Application No: FG/62/26/HH
Site Address: 1 Greenways Crescent Ferring BN12 5EF
Description of works: Proposed detached garden room.

Thank you for your internet representation made on 23rd July 2026 which has been recorded as an objection with the comments as follows:

PROPOSED FOUNDATION PLAN 1:50

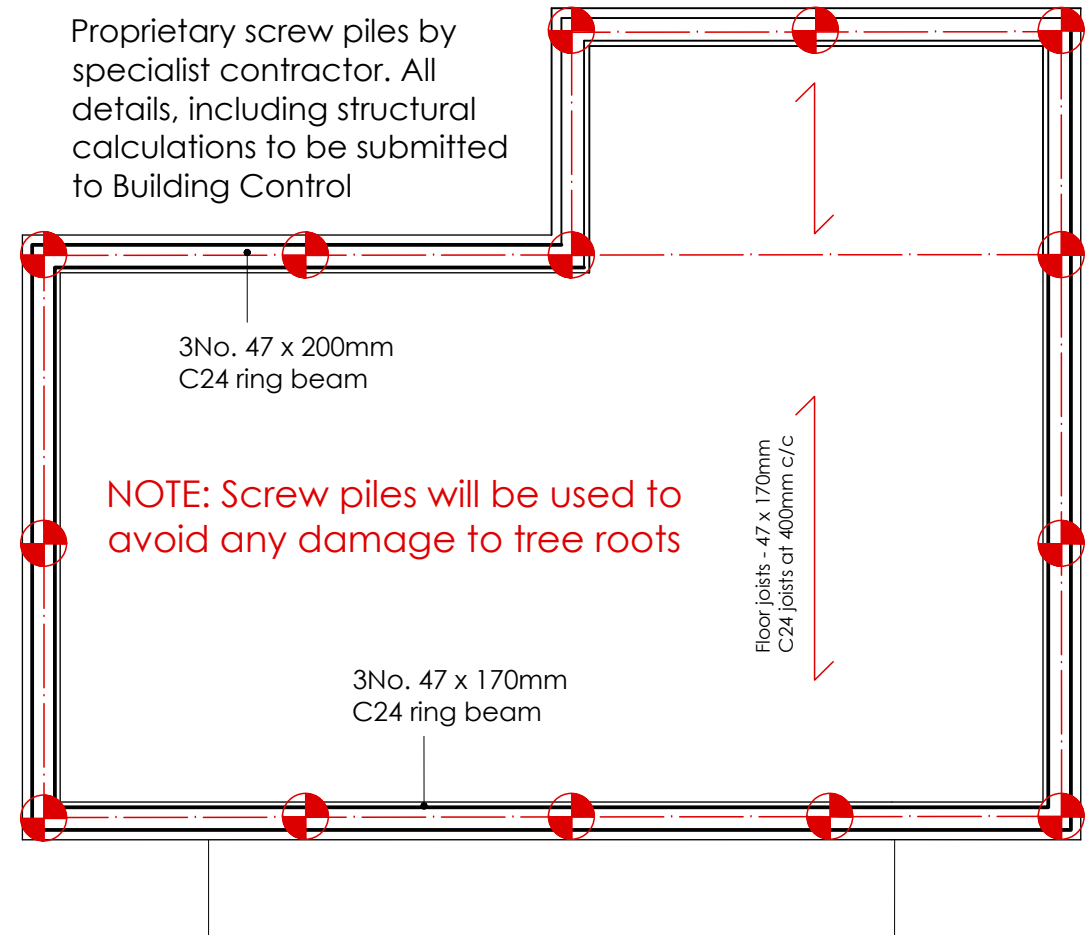
There is a risk to the root systems of existing mature trees which are a pre-dominant feature of the approach into Greenways Crescent. While the application recognises this risk by seeking to limit damage through utilising screw pile foundations, there is no specialist survey with the application which would evidence that existing root systems would not be damaged and long-established trees put at risk.

PROPOSED ARTIST IMPRESSION OF LANDSCAPE DESIGN
(drawing provided by the client)

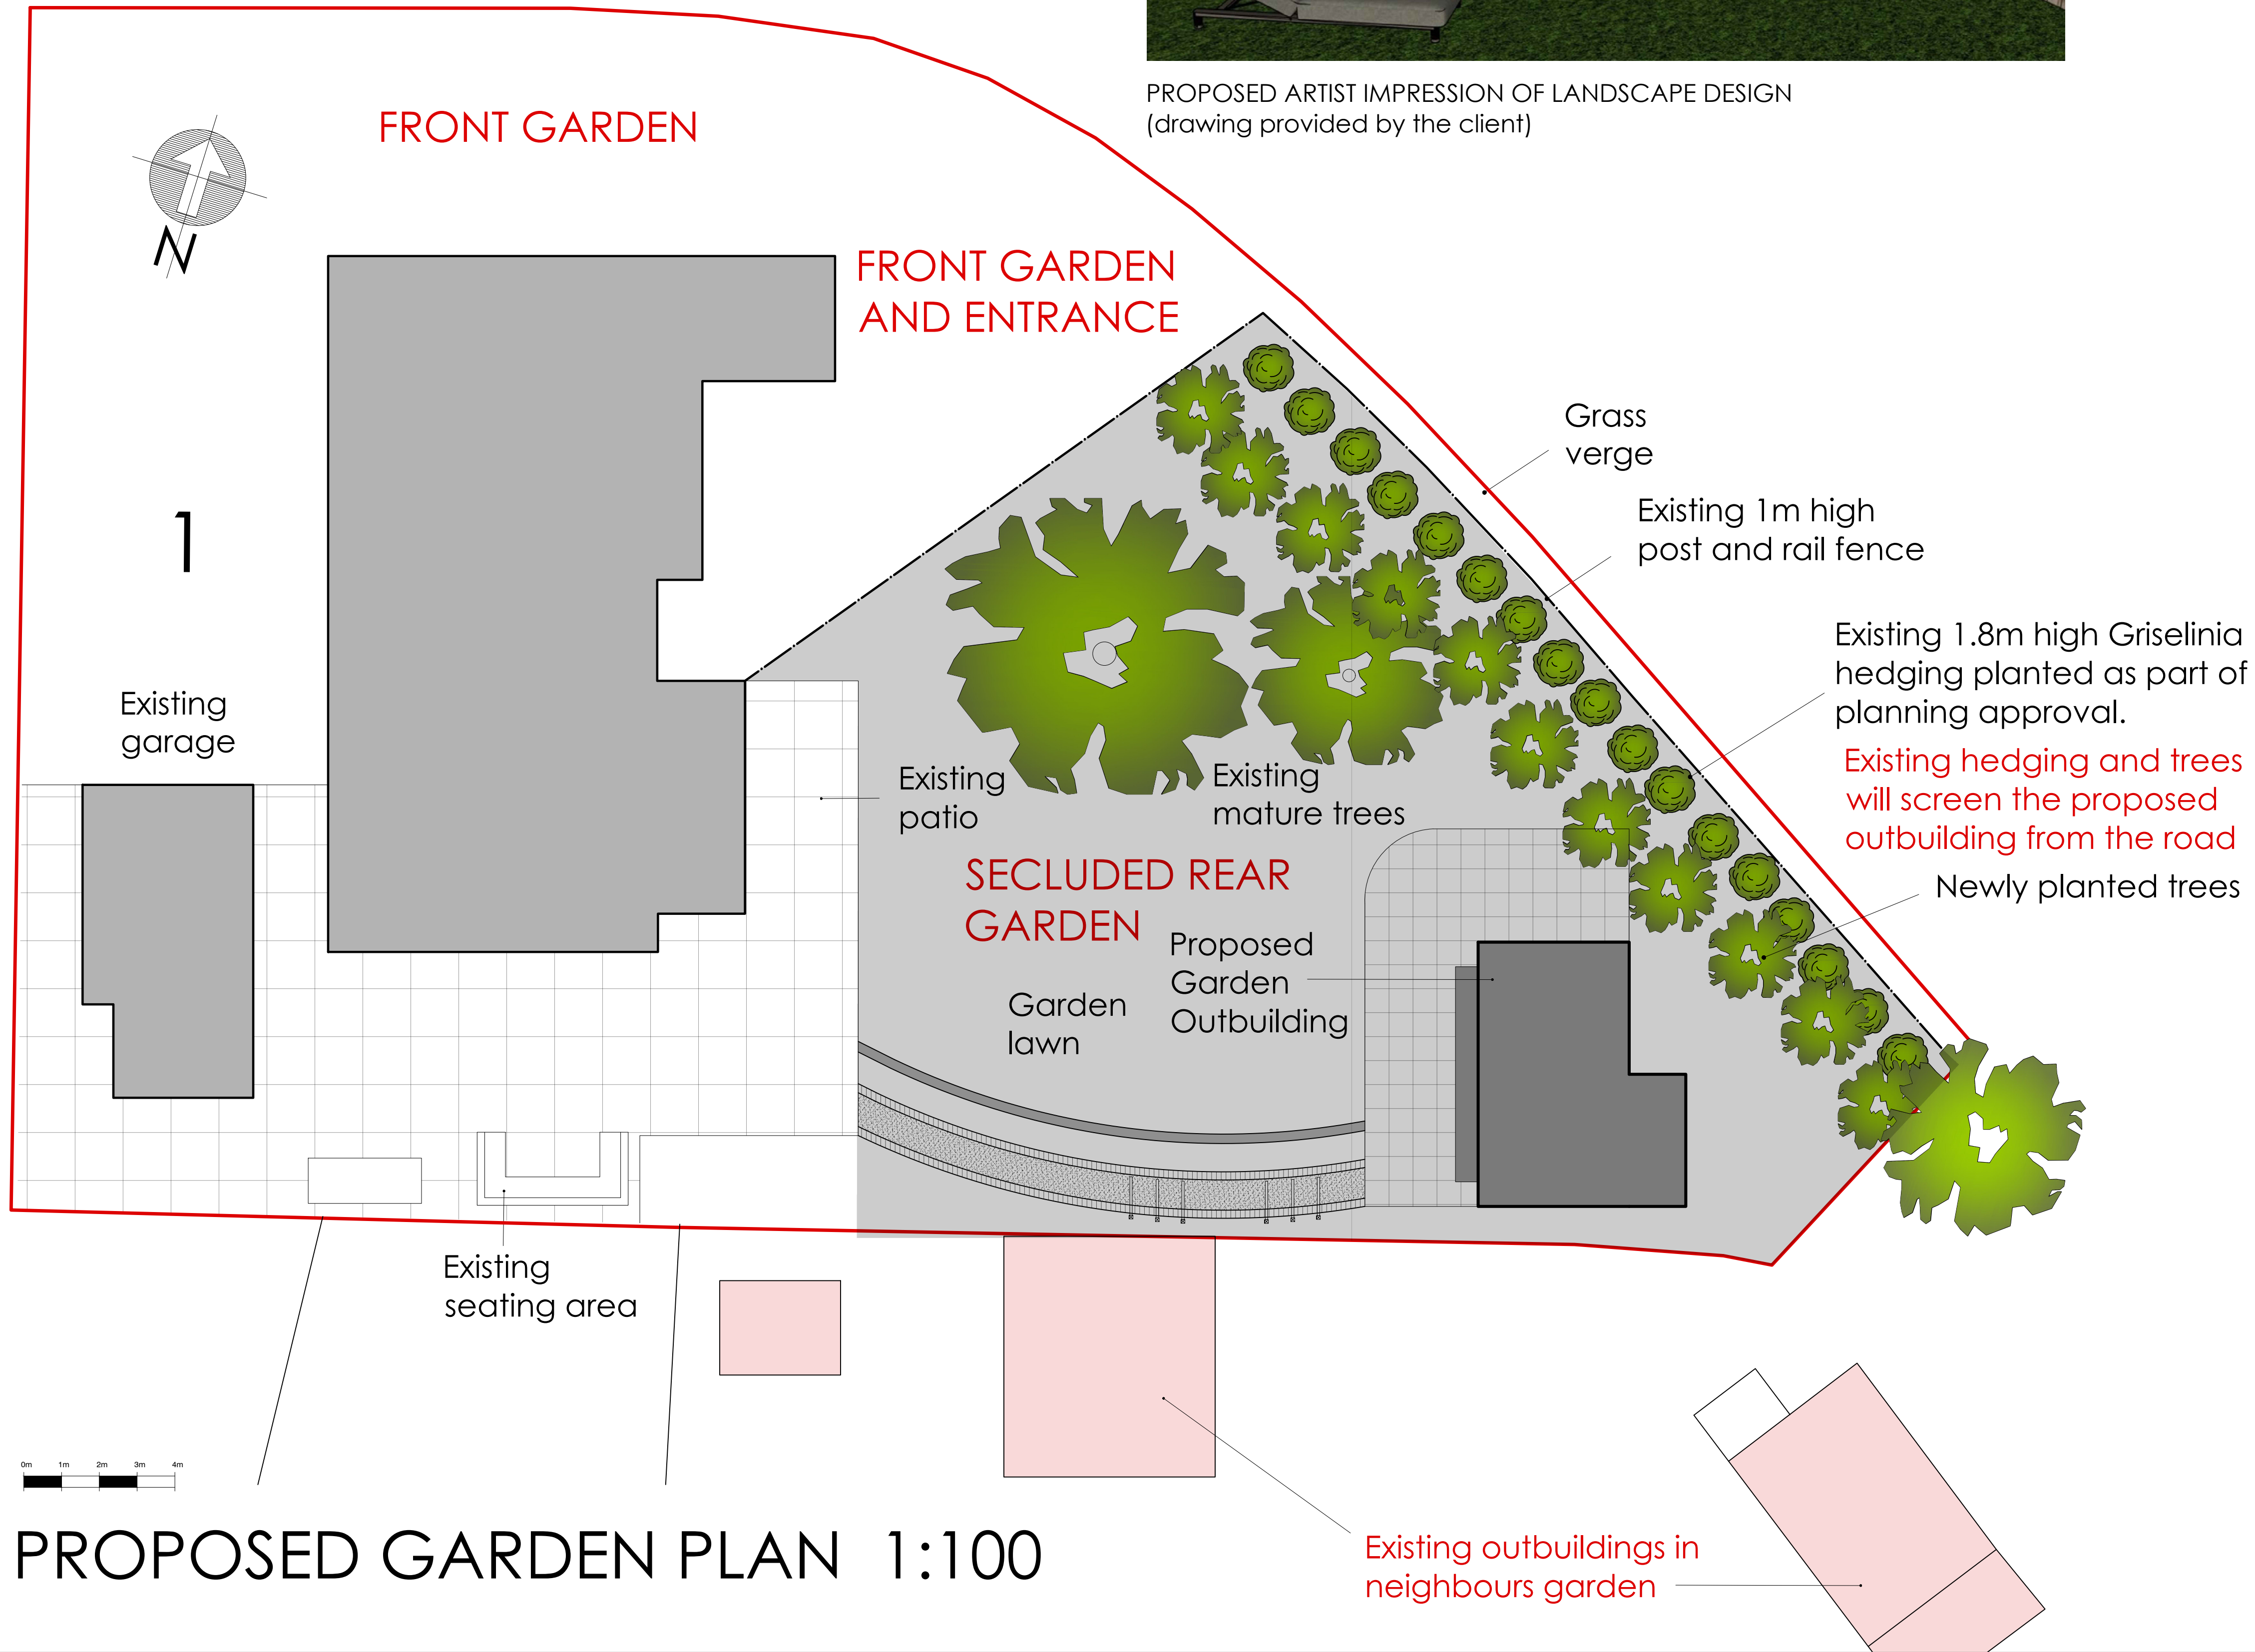
The 'artists impression' provided with the plans is misleading and appears to show a building which does not conform to the dimensions of the latest plans and implies established fencing which is non-existent similar to that refused last year by the planning authority in application FG/32/25/HH. This artist's impression serves no purpose other than to potentially be misleading by making the proposed building appear less intrusive in the street scene.
